From: Amber Willard
Sent: 17 August 2026 13:17
To: Planning.Responses
Subject: FW: WA/57/26/DOC
Attachments: WA-57-26-DOC - Walberton Farm-1 Comment Tracker Arun DC -- Response.docx; 2138-C1 Drainage Construction Details.pdf; 2138-D3 Drainage Layout.pdf; SA1 calcs 1yr Revised FEH22.pdf; SA1 calcs 10yr Revised FEH22.pdf; SA1 calcs 30yr Revised FEH22.pdf; SA1 calcs 100yr Revised FEH22.pdf; SA2 calcs 1yr. Revised FEH22.pdf; SA2 calcs 10yr Revised FEH22.pdf; SA2 calcs 30yr Revised FEH22.pdf; SA2 calcs 100yr Revised FEH22.pdf; Walberton Farm FEH_Descriptors_Micro Drainage 497914_105490.pdf; walberton farm.docx

WA/57/26/DOC

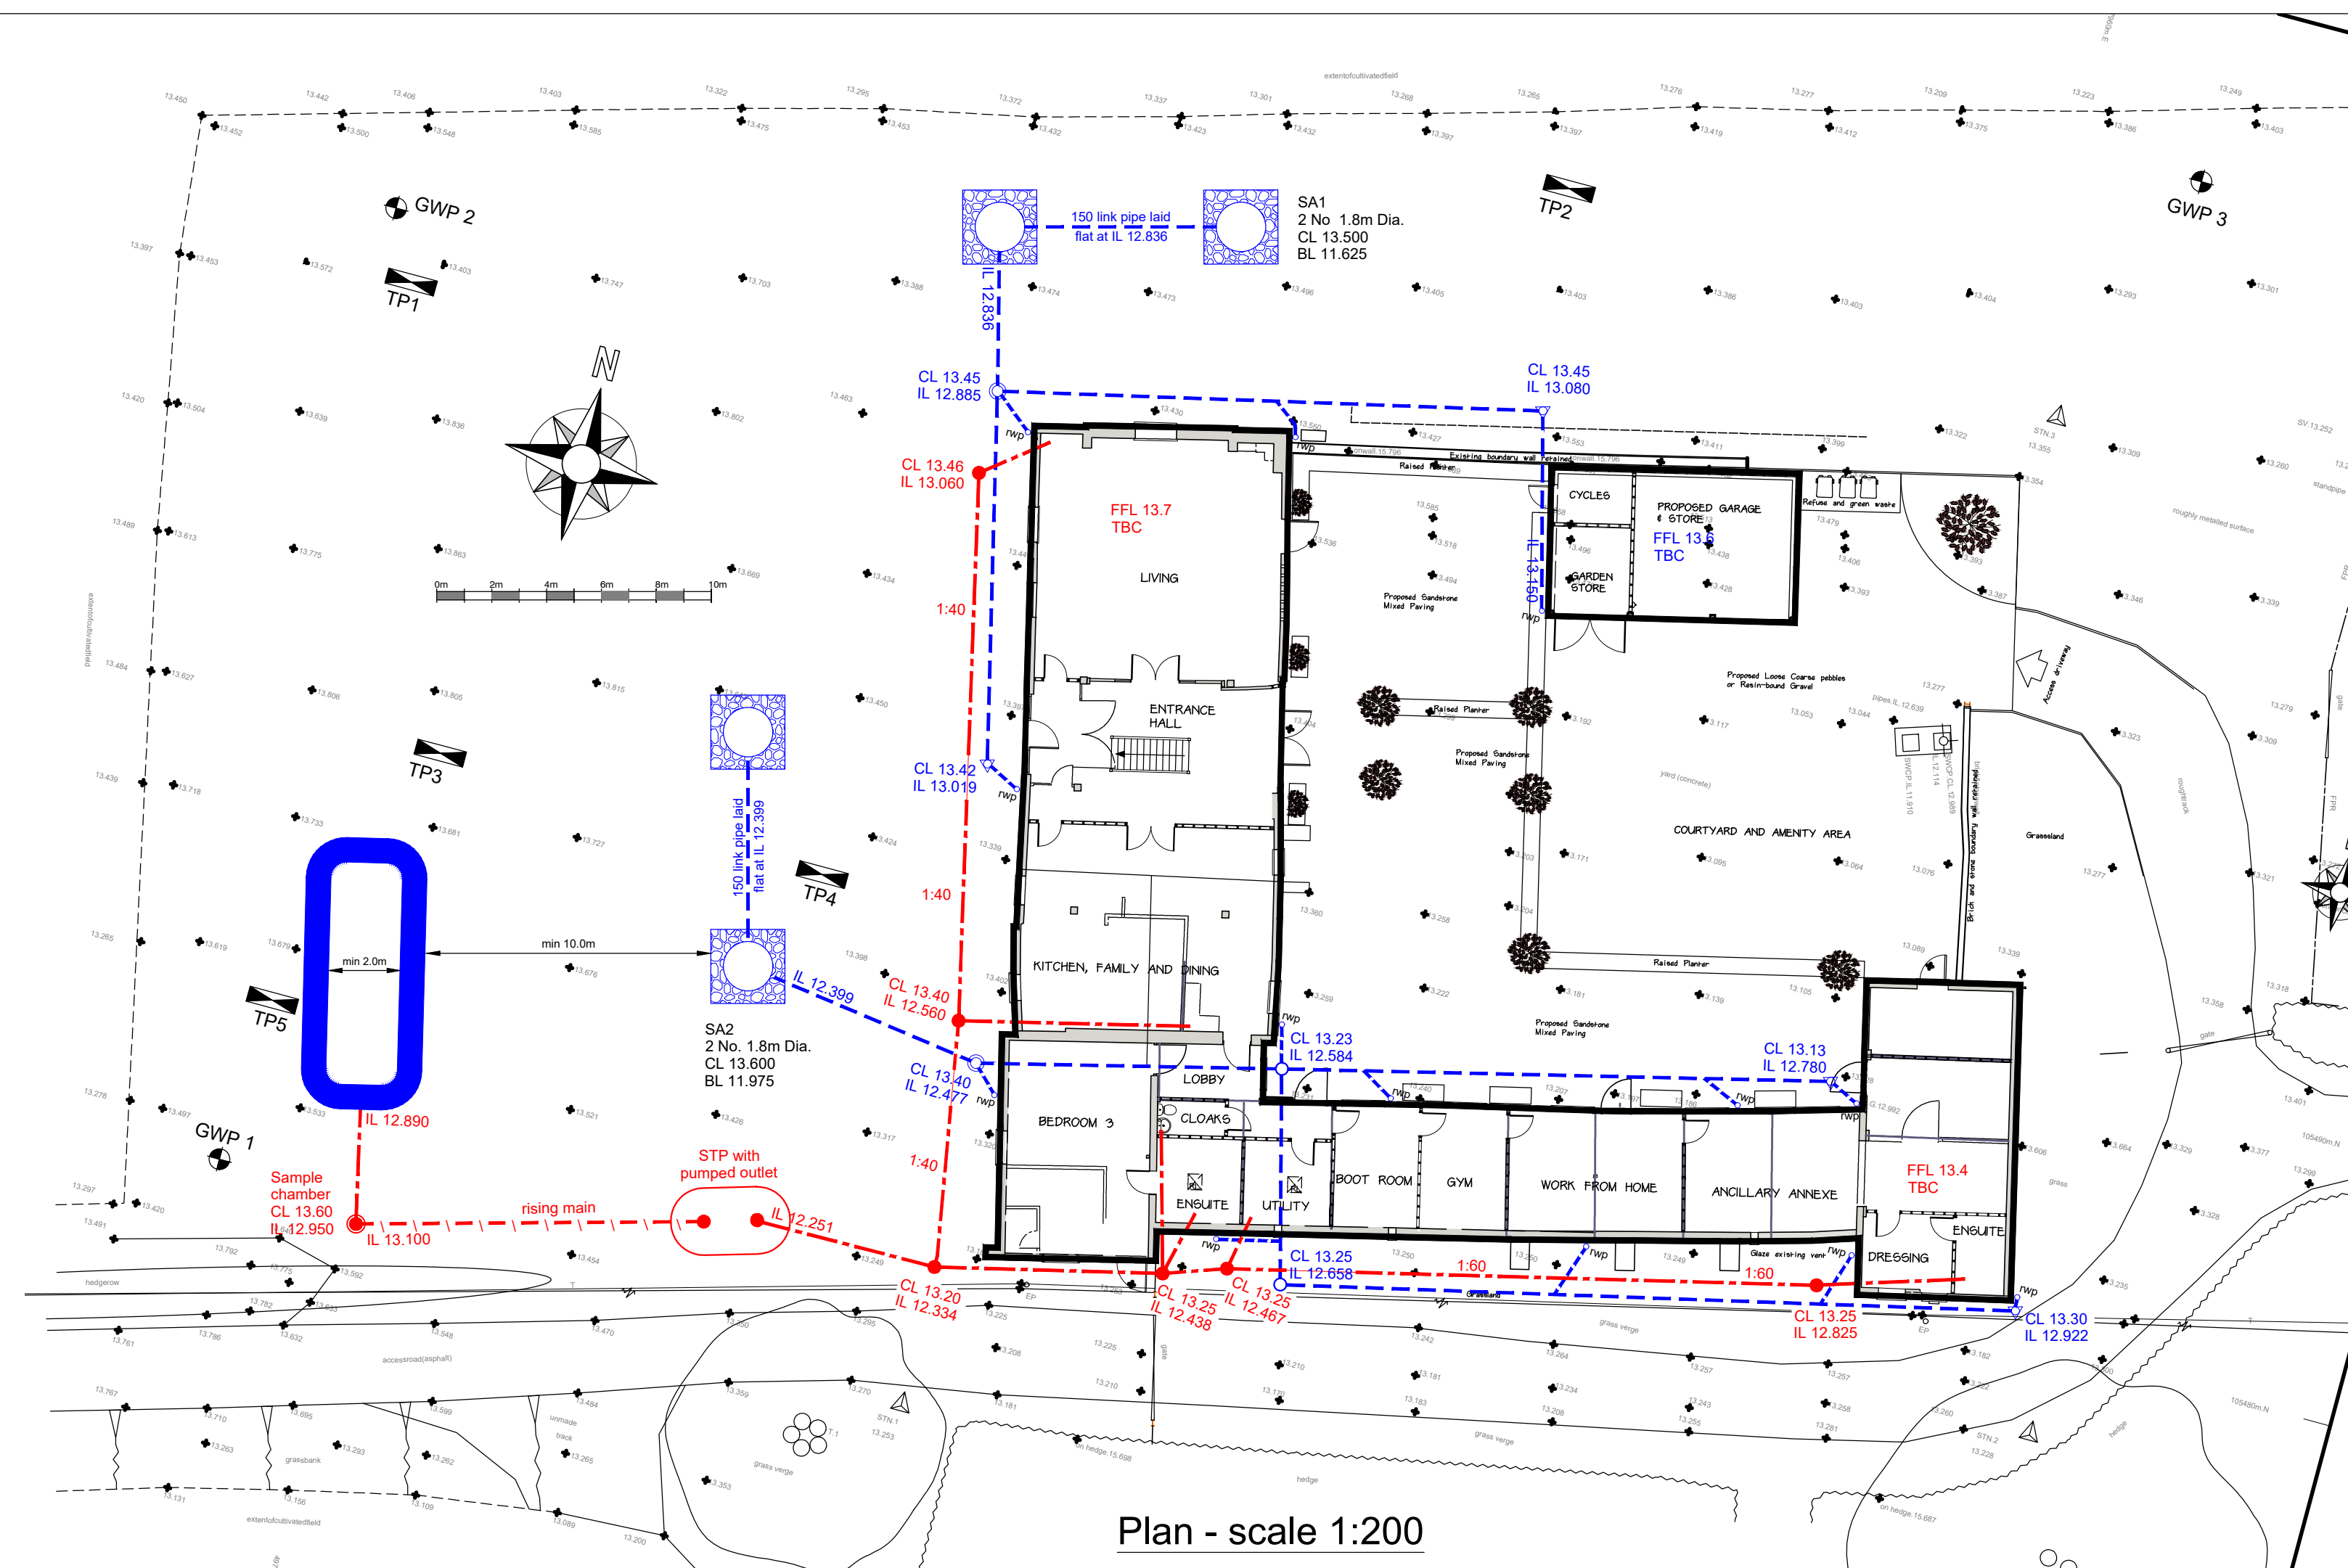
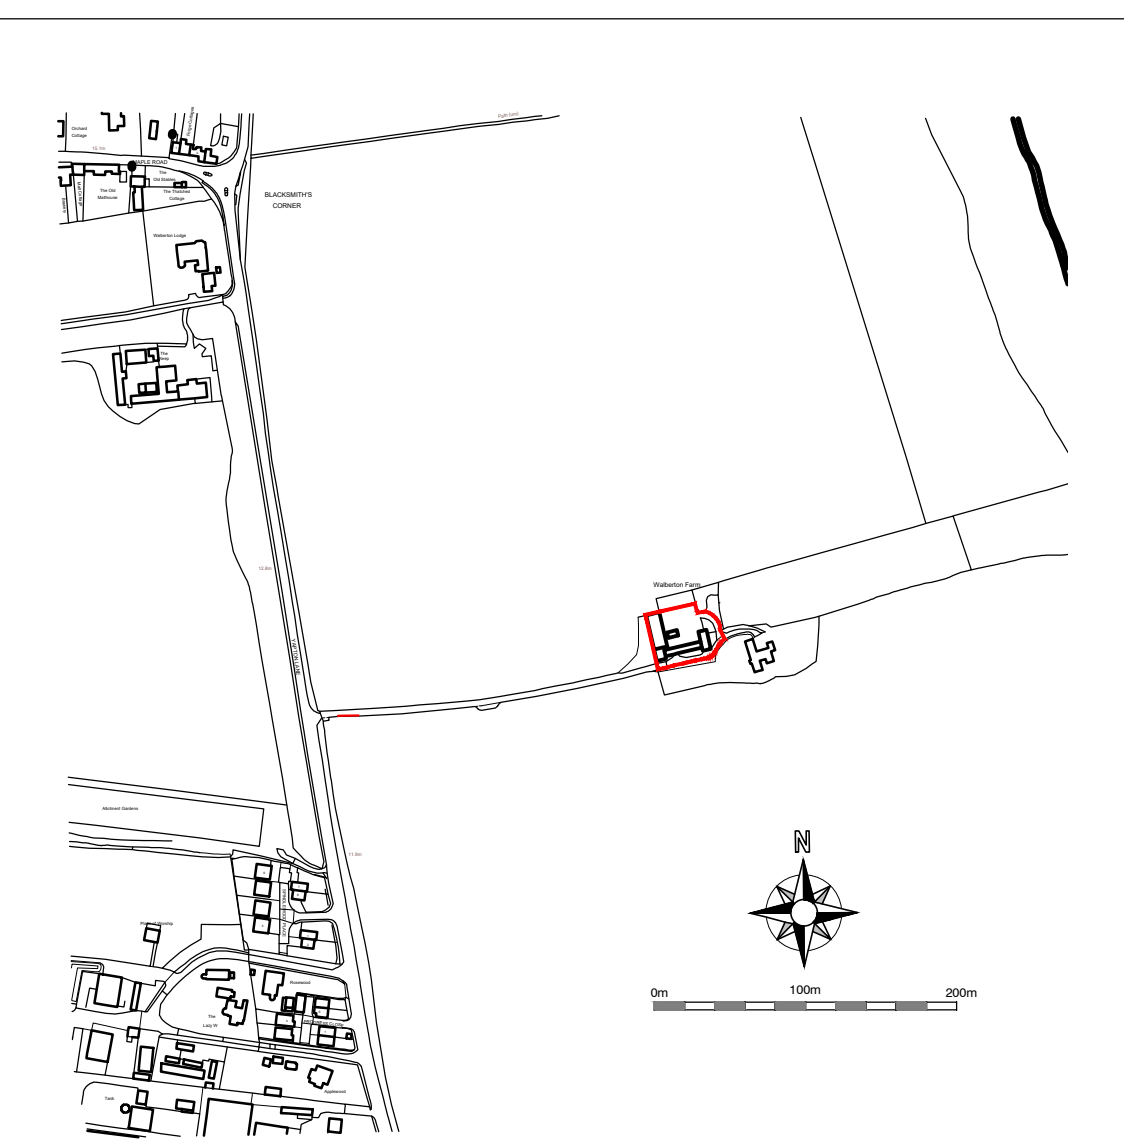
See attached our drainage consultant's response to the points raised.

- a) A revised Drainage Layout drawing
- b) Construction Details drawing
- c) 4 sets of calculations for each of the two soakaway system
- d) The Descriptors file used by Micro Drainage for the calculations.
- e) The Comment Tracker completed
